CITY OF ALBUQUERQUE

June 29, 2017

**RE: Oakland Ridge Subdivision
Grading Plan and Drainage Report
Stamp Date: 6/27/17
Hydrology File: C18D085**

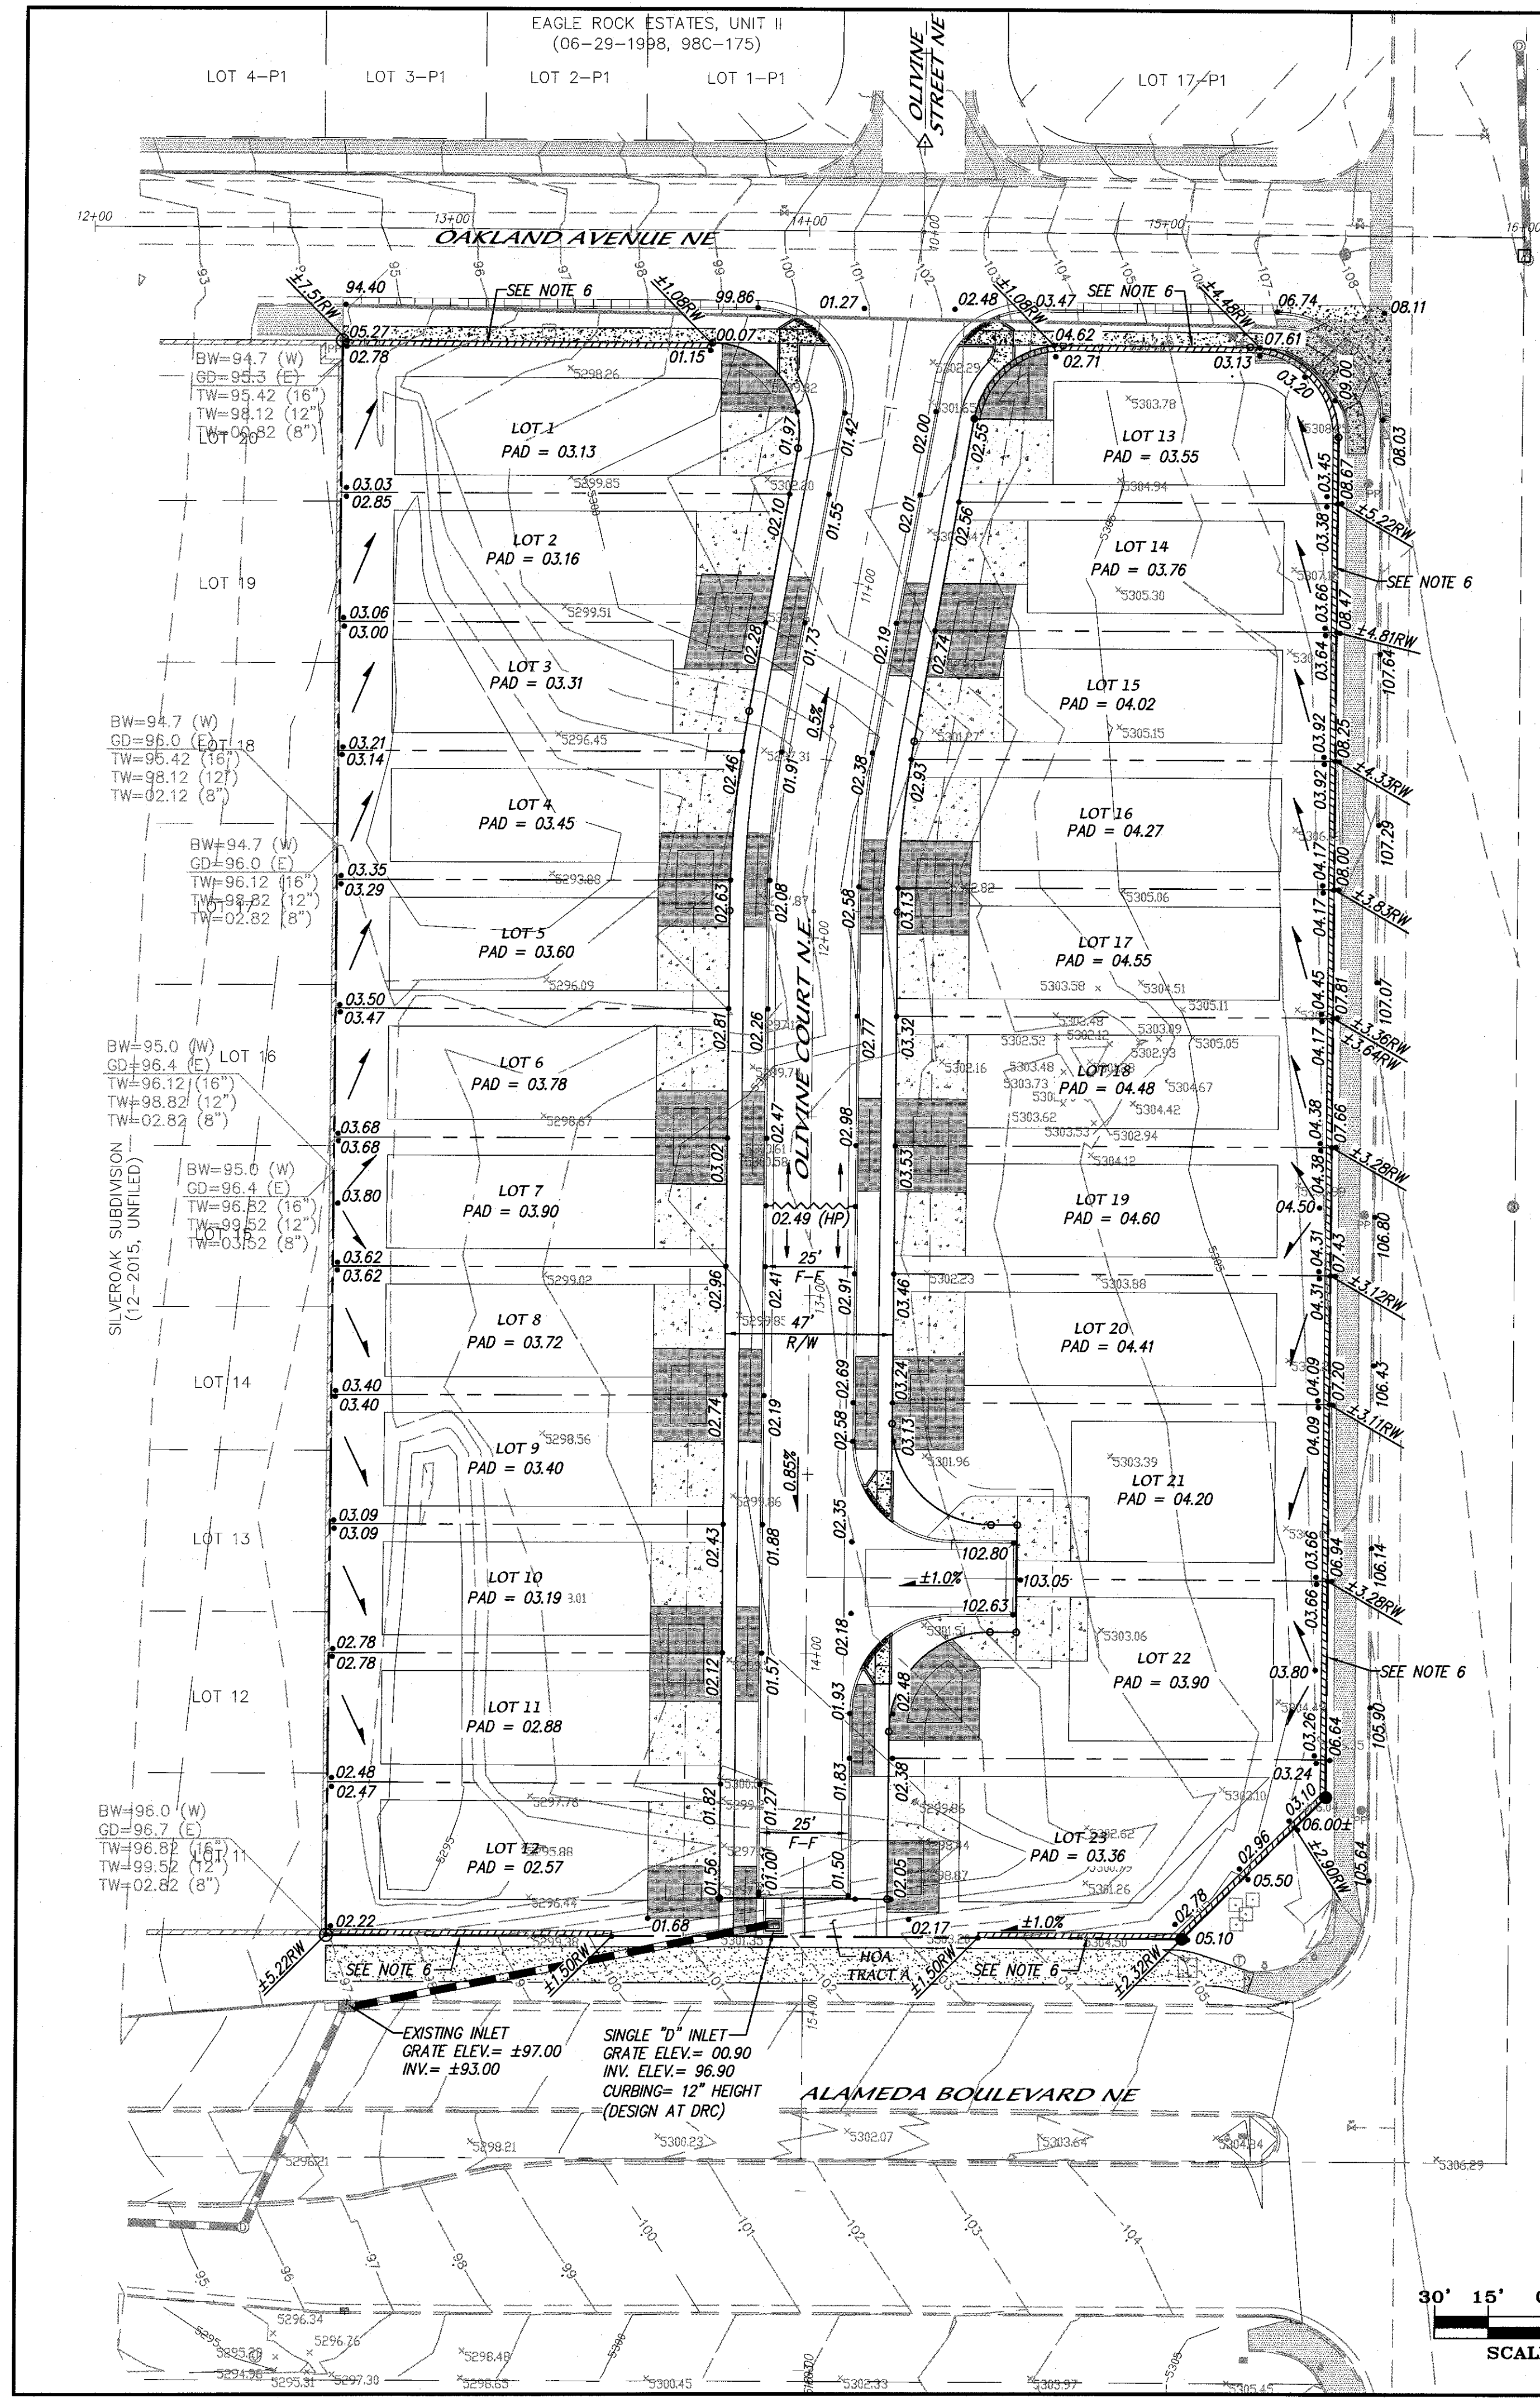
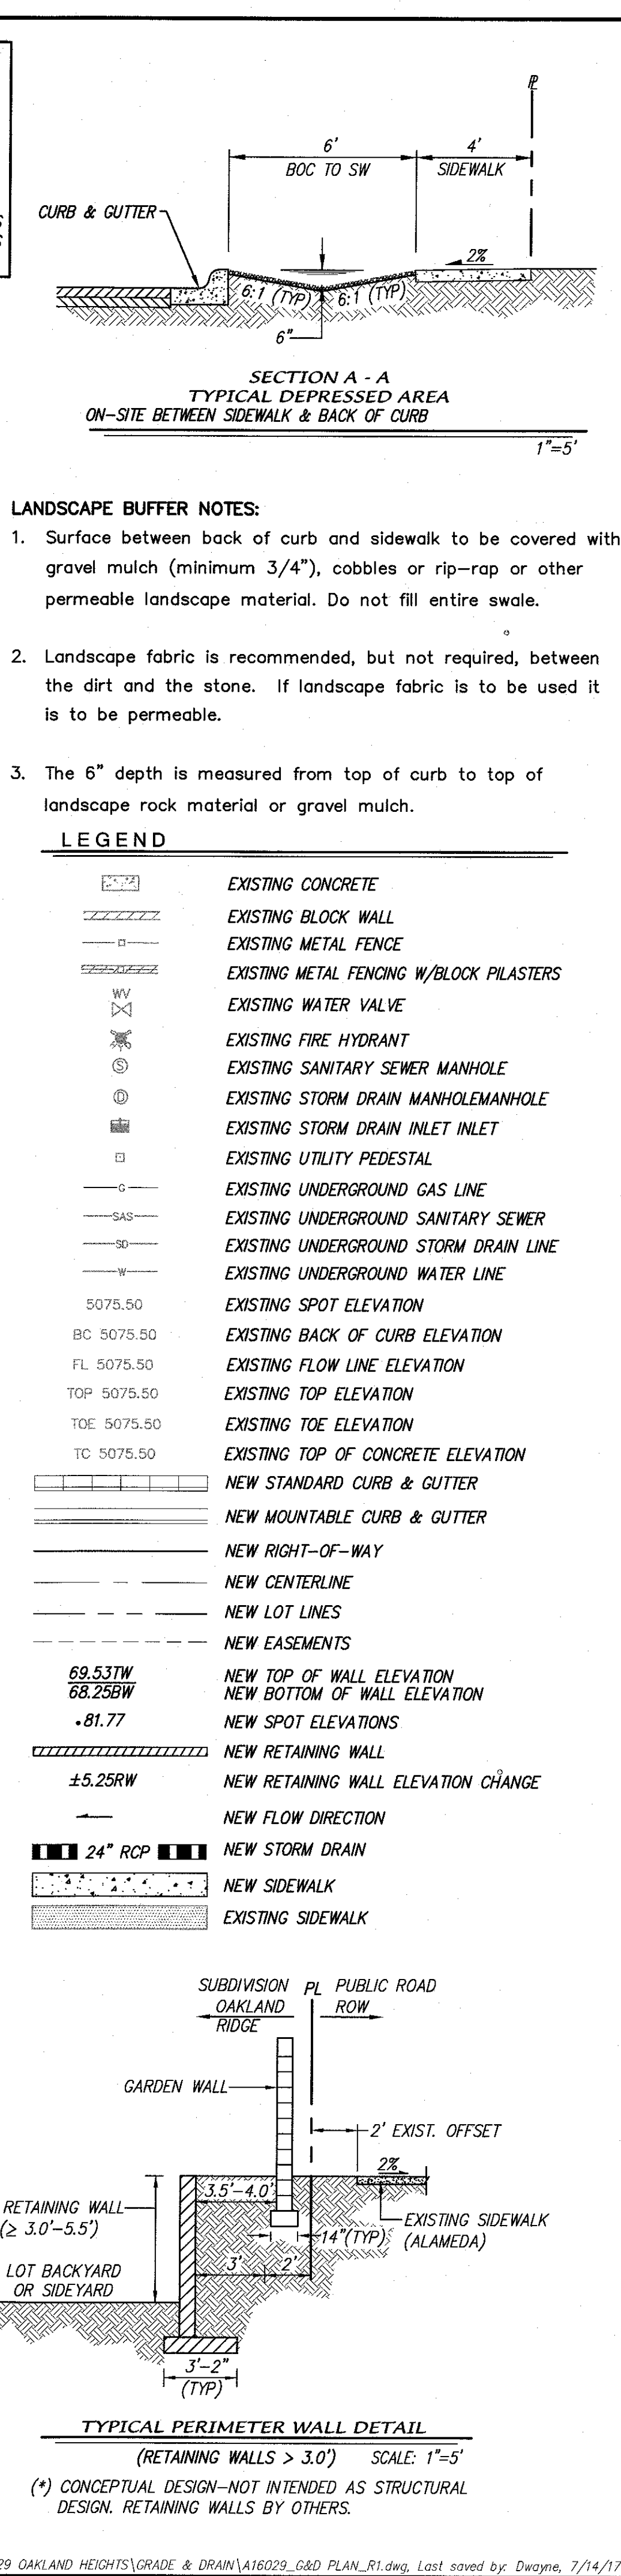
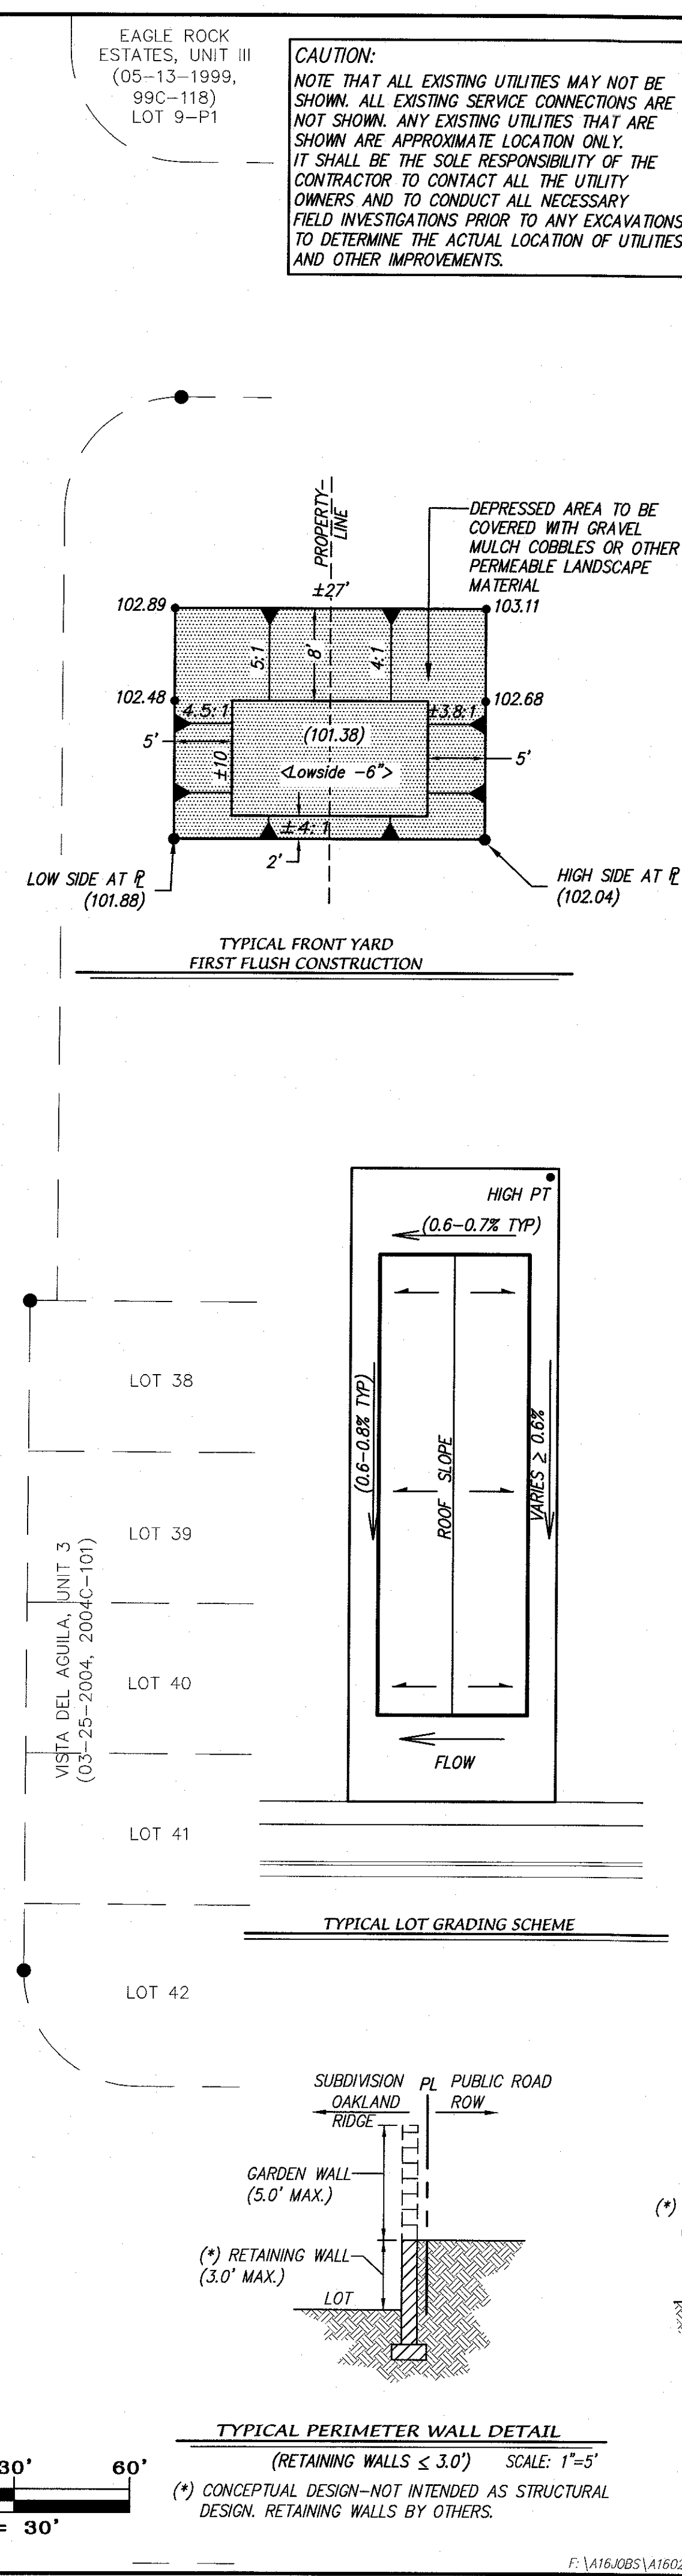
Please note that before a submittal for building permit; please verify that the inlet on Oakland that you show at the northwest corner of the property exists. It appears that this inlet was not installed by the adjacent development.
